Our Ref: Y/87/19/HH

**Town & Country Planning Act 1990 (as amended)
Town & Country Planning (Development Management Procedure) (England) Order 2015
Application for Planning Permission for Works or Extension to a Dwelling**

Development Single storey rear extension

Location 8 Mill View Road Yapton

Proposed Floor Plans

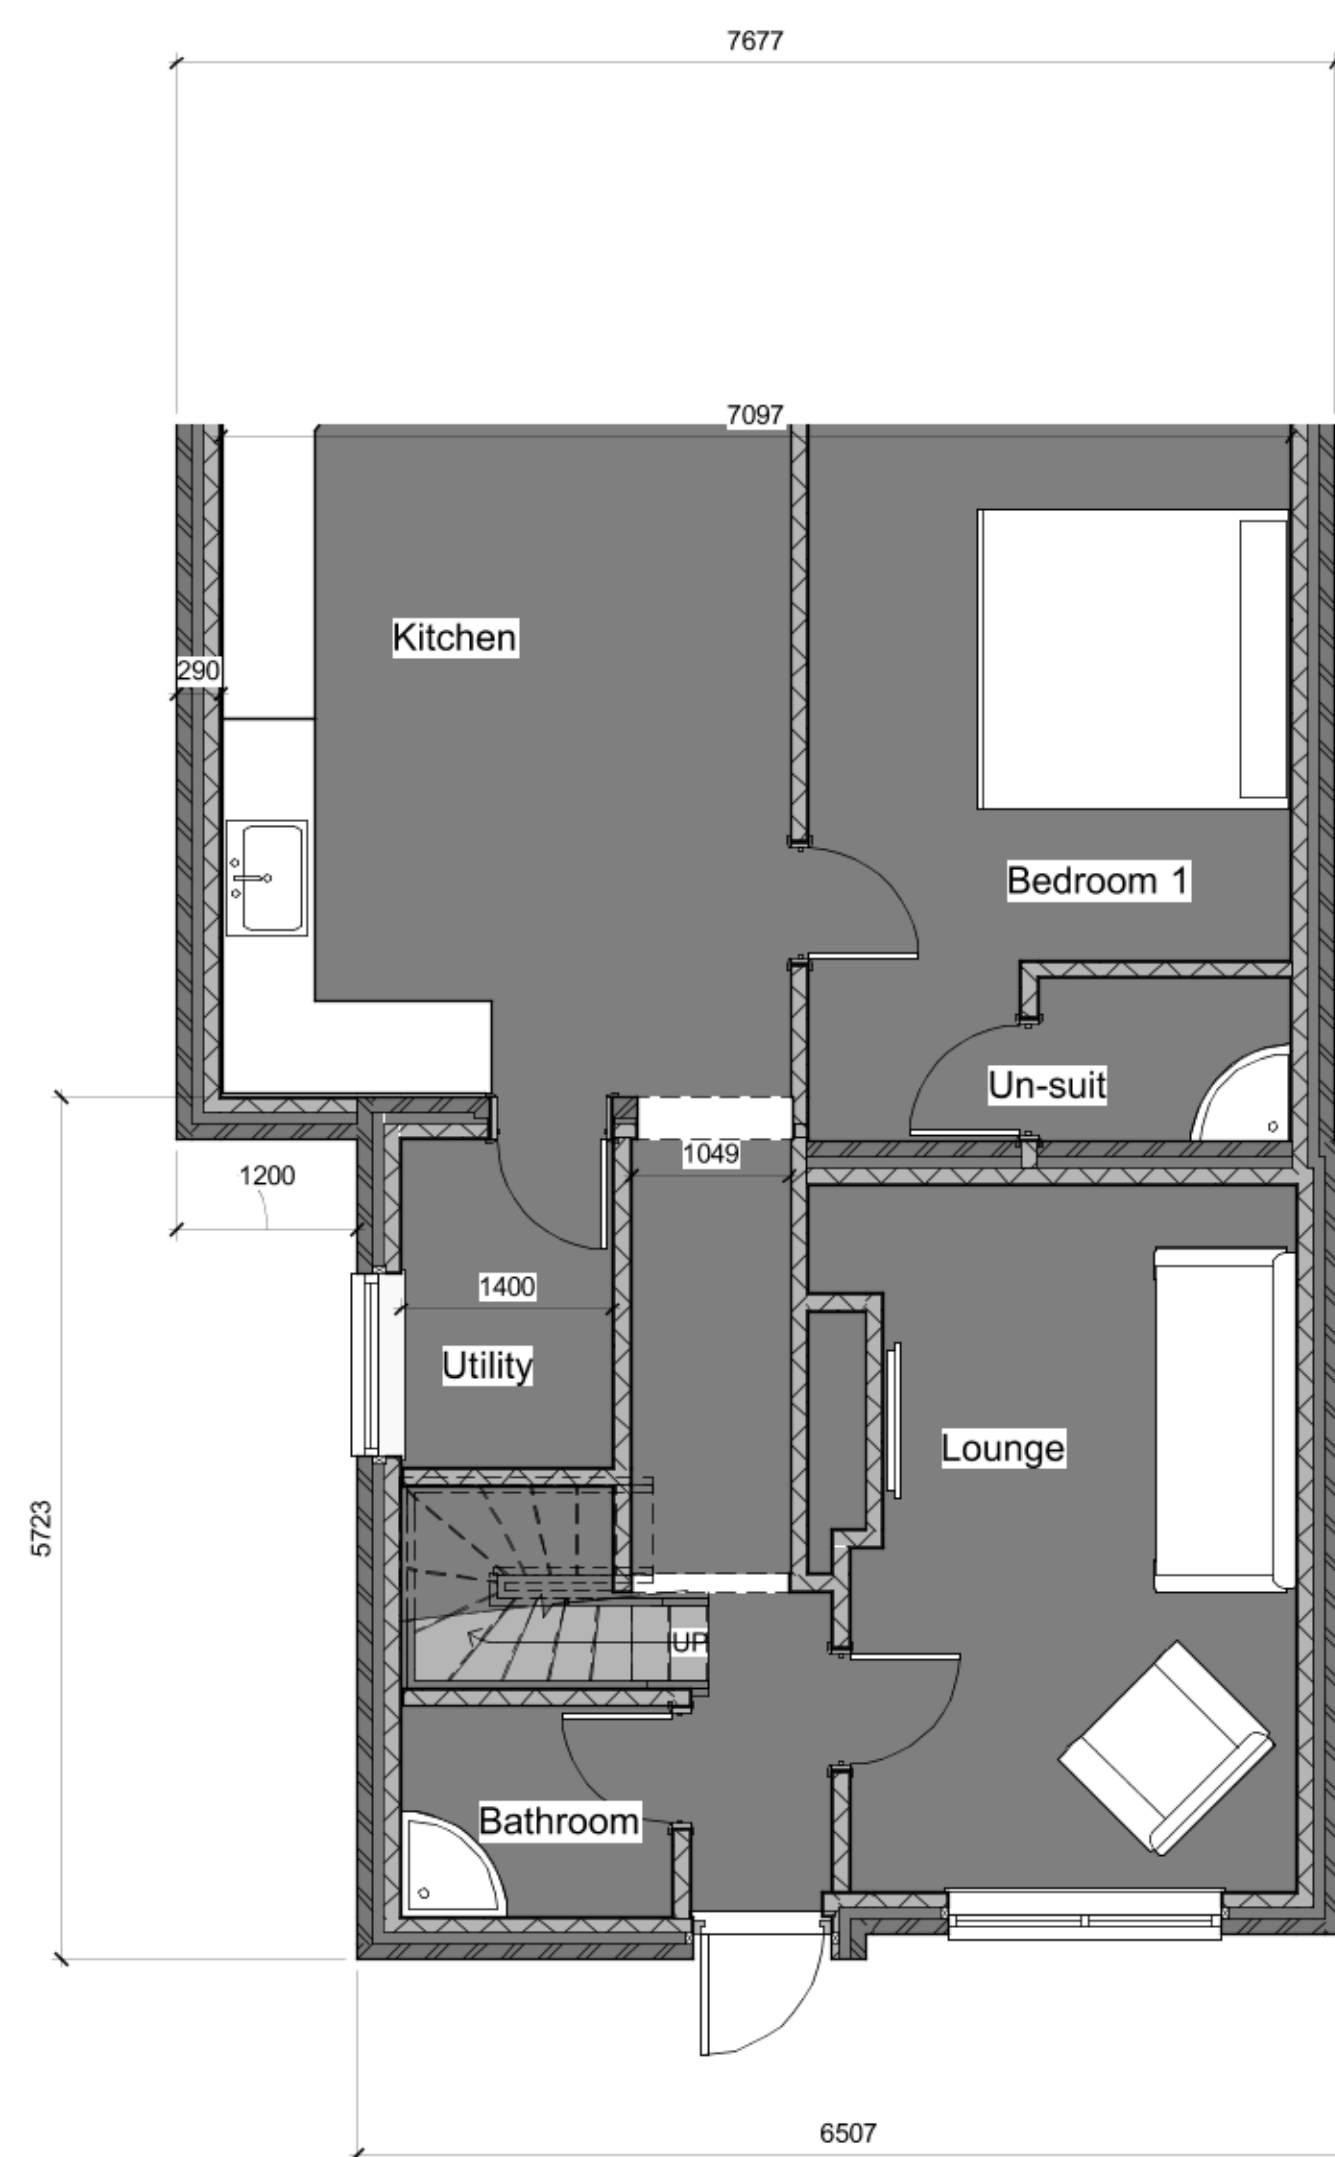
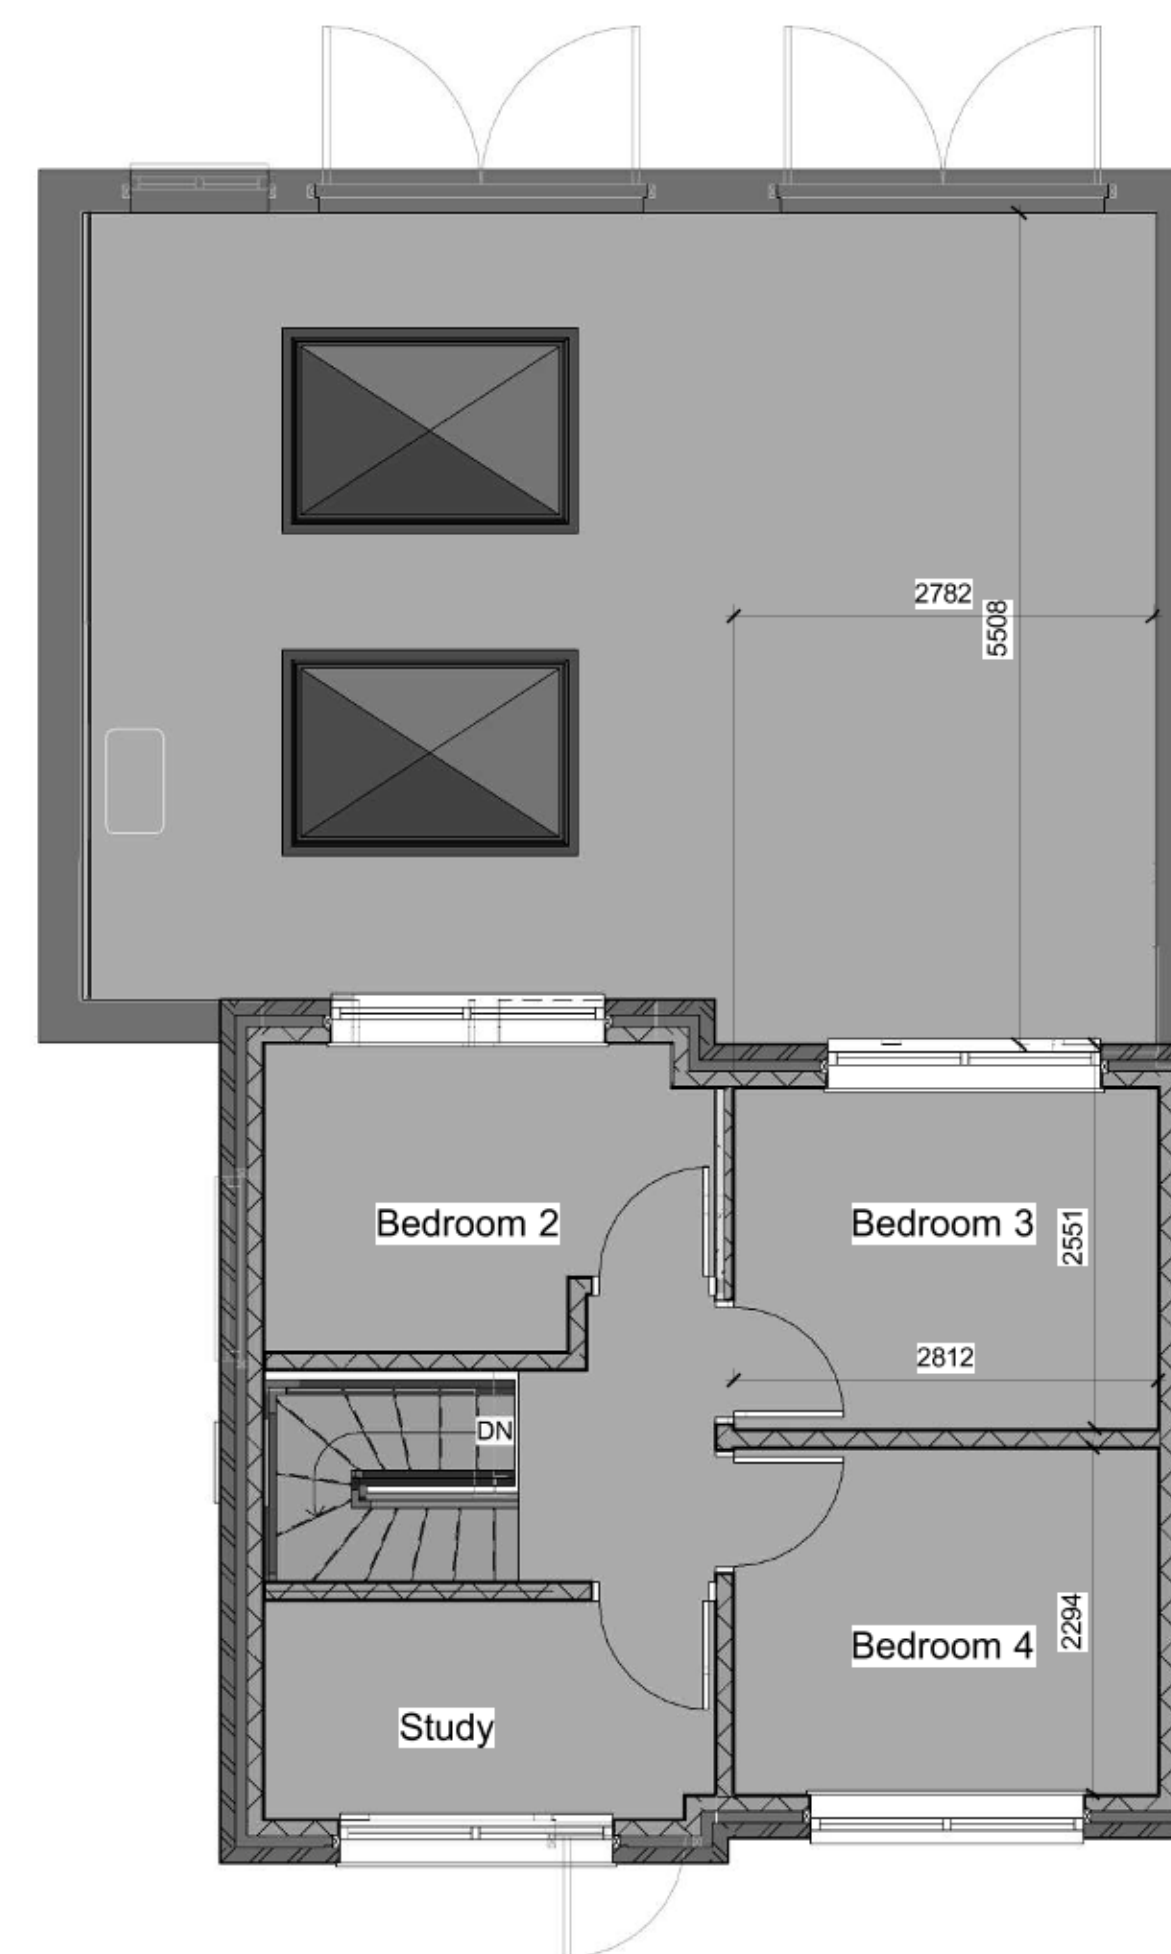
The proposed floor plans do not measure correctly to the stated scale of 1:50.
